**Brandy Hill Quarry Expansion Project SSD 5899
Comments on the Addendum to the Air Quality Impact Assessment Report**

Reference is made to your email to the Environment Protection Authority (EPA) dated 7 June 2019, seeking the EPA's comments and/or advice on the Addendum to the Air Quality Impact Assessment (AQIA) Report submitted to the Department of Planning and Environment (DPE) for the Brandy Hill Expansion Project, SSD 5899.

Figure 9-1: Number of Days the 24-Hour Average Incremental Predictions Exceed the PM₁₀ Criteria

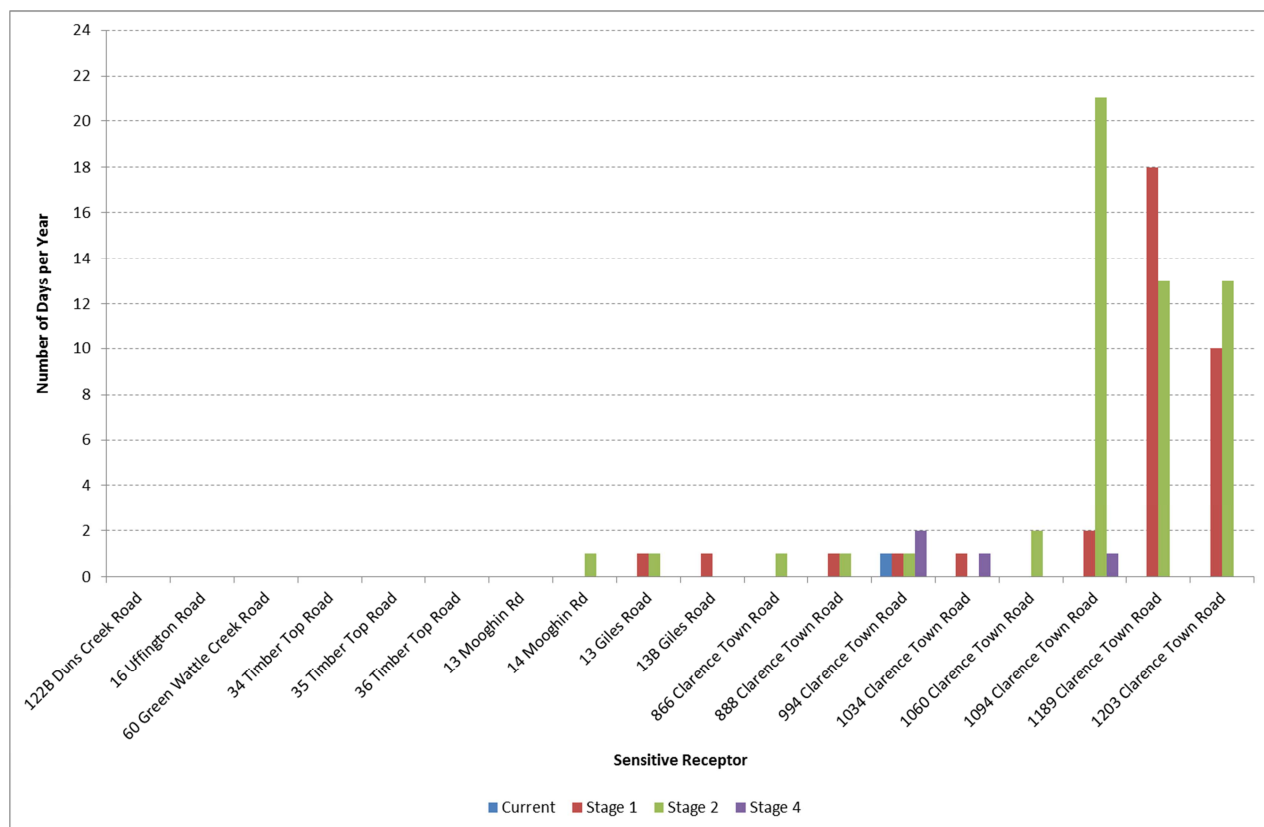
Background concentrations for cumulative analysis was obtained from the OEH Beresfield station. At each receptor, there were five occasions where the PM₁₀ concentrations in the background data exceeded the 24-hour average PM₁₀ criterion of 50 µg/m³. The total impact of the project (i.e. incremental and background concentrations) on these 5 occasions were not provided. As requested in earlier advice, results (incremental and background) on days that had exceedances should be provided for each receptor.

Results of the revised dispersion modelling should include the concentration (background and incremental) at each receptor when there are exceedances.
